**Ref: GREAT NORTH ROAD SOLAR PARK DEVELOPMENT CONSENT ORDER (DCO)
EN010162 – THE EXAMINING AUTHORITY’S WRITTEN QUESTIONS EXQ1**

I write in response to the Examining Authority’s (ExA’s) written questions and requests for information (ExQ2) issued on 4th March 2026 and to provide the response of Nottinghamshire County Council (NCC) (Interested Party [REDACTED]) in relation to those questions which are addressed directly to NCC, or the Interested Parties where relevant to the responsibilities of NCC.

Will Lawrence MRTPI
Planning and Infrastructure Manager
Nottinghamshire County Council

Site Access Locations
Figure 14.4 NE

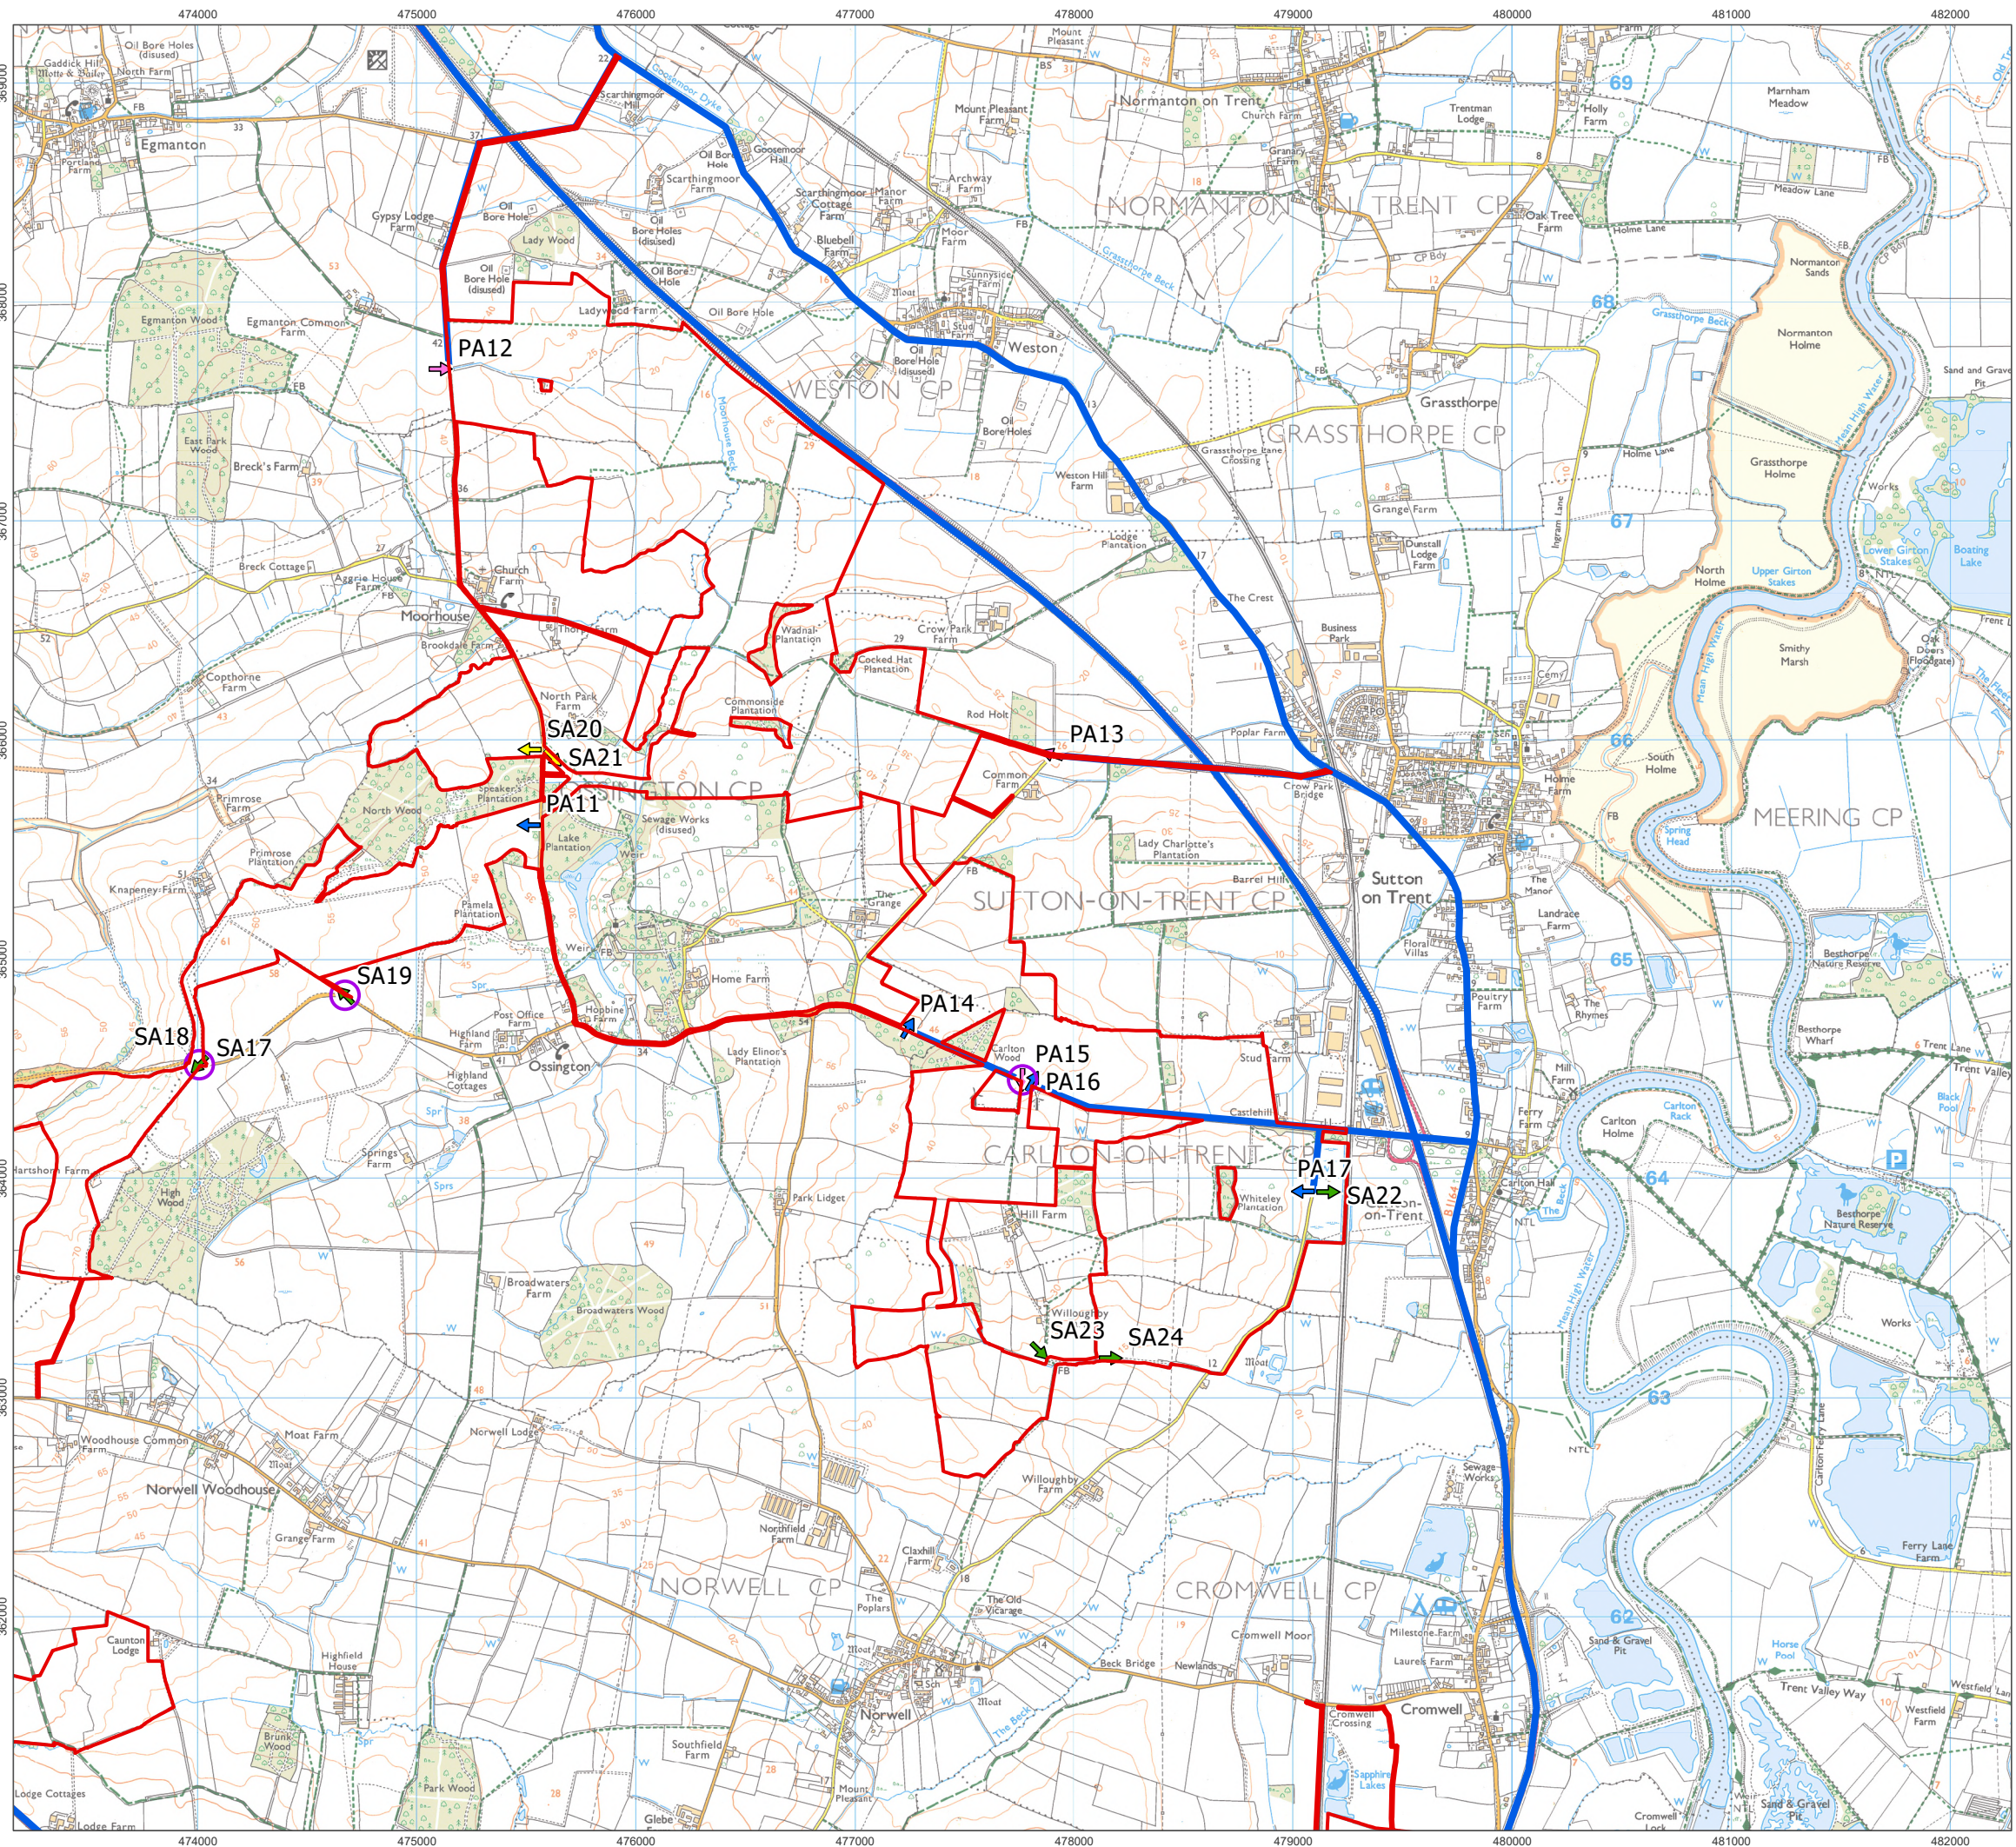
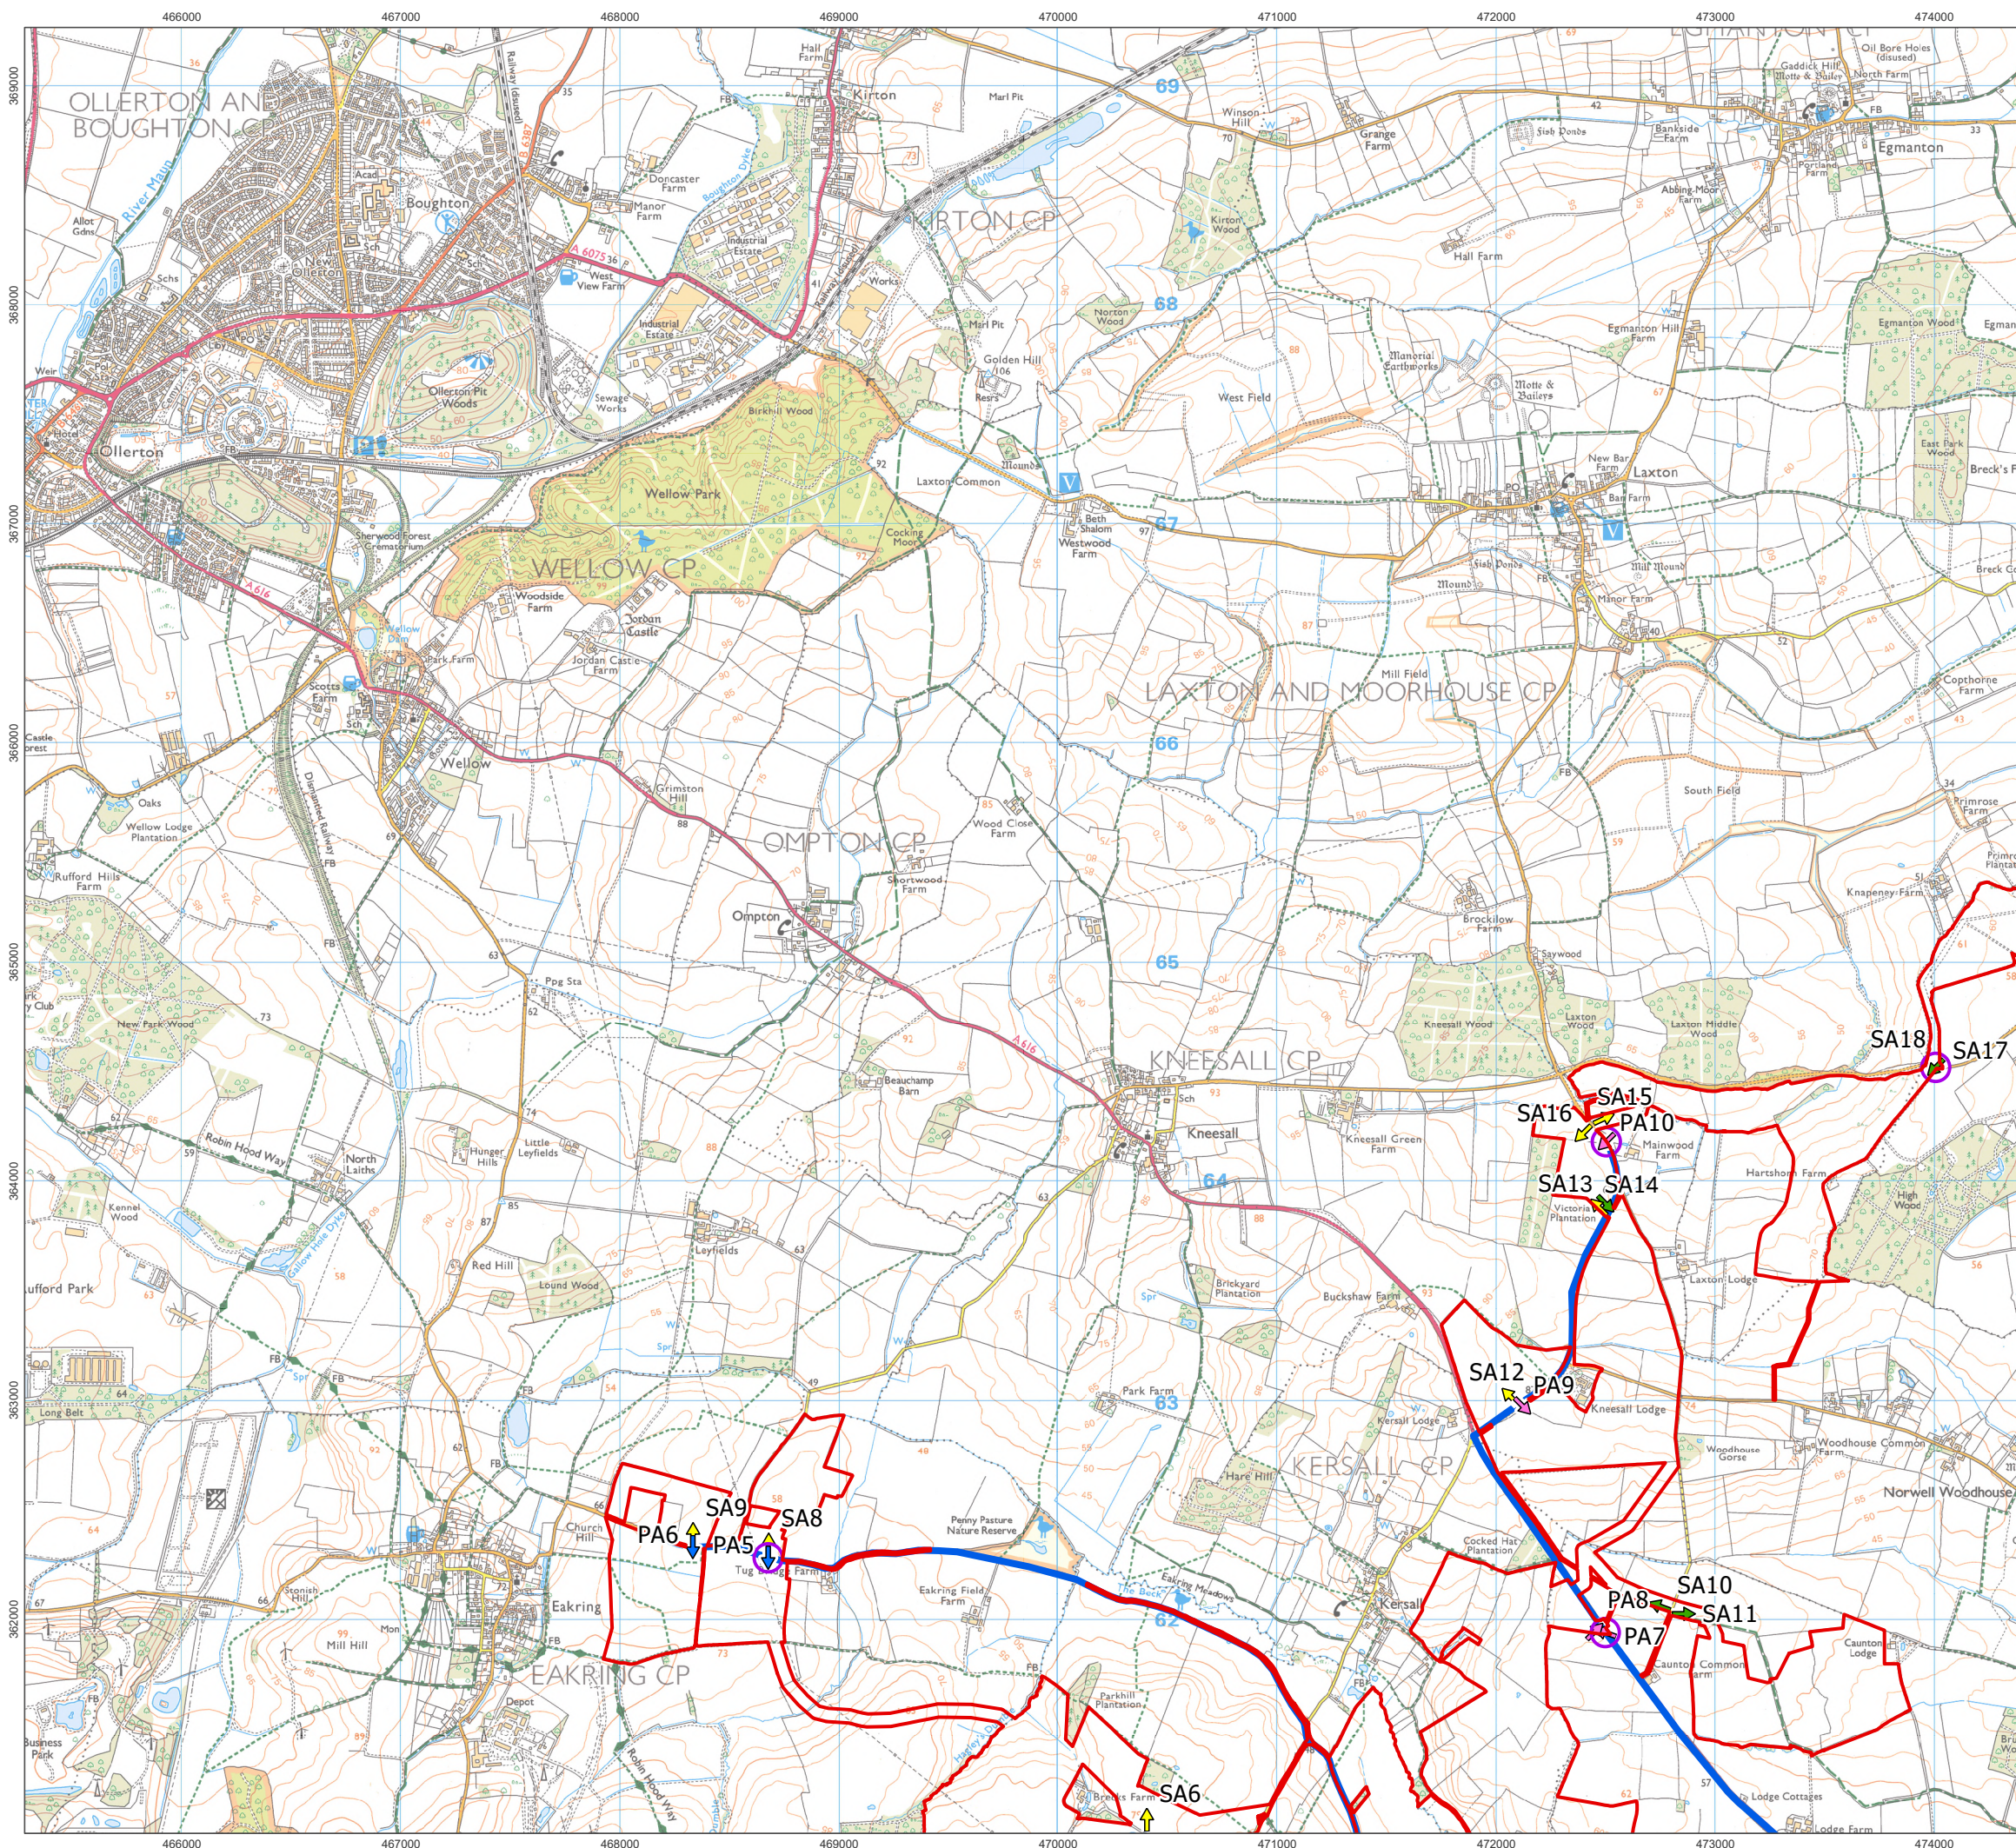
7. Construction Effects			
Q7.2.1	NCC	<p>Site access</p> <p>The ExA understands from the deadline 3 SoCG between the applicant and NCC [REP3-070] that there remain outstanding issues including site access design drawings and safety audits.</p> <p>(a) Does NCC consider that the powers and controls in the dDCO [REP3-005] including articles 16,18 and requirement 14, in association with the outline construction traffic management plan (oCTMP) [REP3-035] are insufficient to prevent an unacceptable impact on highway safety?</p> <p>(b) If the answer is yes please could NCC provide proposed amendments to the dDCO and the oCTMP?</p>	<p><u>Part (a):</u></p> <p>Yes – the controls in the dDCO and the OCTMP are insufficient to prevent an unacceptable impact on highway safety. This is because there are several accesses that do not meet the required visibility standards or have not been properly demonstrated to meet the required visibility standards. It is noted that the applicant is proposing to control visibility deficiencies during the construction phases through vegetation and traffic management, however the vast majority of the accesses are intended to remain in use during operation with no maintenance regime proposed.</p> <p>In total, there are 15 accesses where hedges are required to be coppiced to 0.6m during construction and a further 9 accesses where hedges are required to be trimmed back during construction. Whilst the oCTMP makes allowance for their maintenance during construction, there are no proposals for maintenance during the operational phase, and nor is this considered to be practical where coppicing is required as this results in vigorous growth. The applicant has proposed use of banksmen during the operational phase at such accesses where visibility is deficient. This would mean that banksmen (second operatives) will be crossing roads where visibility has been proven to be deficient. The suggested methodology also introduces a convoluted and unrealistic access regime.</p> <p>There are also highway safety concerns that do not relate to visibility but instead arise from their interaction with the surrounding network. There are 4 accesses with possible layout safety issues (not necessarily visibility related). In the case of PA01, the access is located on the A617 in close proximity to a signal controlled</p>

<p>junction. This creates a risk that drivers approaching on a green signal will not anticipate vehicles ahead slowing or stopping to turn into the access. This risk is heightened during the operational phase, when the access will not be temporarily signed and heavily used, and is instead likely to be used by smaller, faster moving vehicles rather than the larger, slower agricultural vehicles currently associated with the site.</p> <p>Both the above access on the A617 and those proposed on the A616 fall on the Nottinghamshire 'resilient network' which are considered to form part of our major road network, falling just below trunk road category and are therefore of significant importance. It is therefore considered key that such proposals are demonstrated to be acceptable prior to consent.</p> <p>There are 19 accesses where speeds have been assumed which means that the visibility spays are in abeyance. Relevant speed surveys are required to establish if the visibility splays are adequate.</p> <p>Furthermore, the applicant has also not provided any further information in relation to the passing bays and their intervisibility, to confirm safety.</p> <p>In summary, NCC believes that there are fundamental safety issues with a significant number of accesses that would be authorised by the DCO and that the issues cannot be adequately addressed during the operational phase.</p> <p><u>Part (b):</u></p> <p>The Applicant should address the fundamental visibility issues described above and provide a Stage 1 Road Safety Audit for those accesses where there are possible layout safety issues prior to consent being granted to demonstrate that the access points and passing bays are safe.</p>

<p>If these issues cannot be addressed, then the accesses and passing bays should not be authorised by the DCO and alternative locations would need to be assessed by the Applicant. NCC is concerned that the DCO explicitly (via Article 16) provides authority for the undertaker to create accesses in the locations (listed at Schedule 6) which are not demonstrably safe in principle.</p>
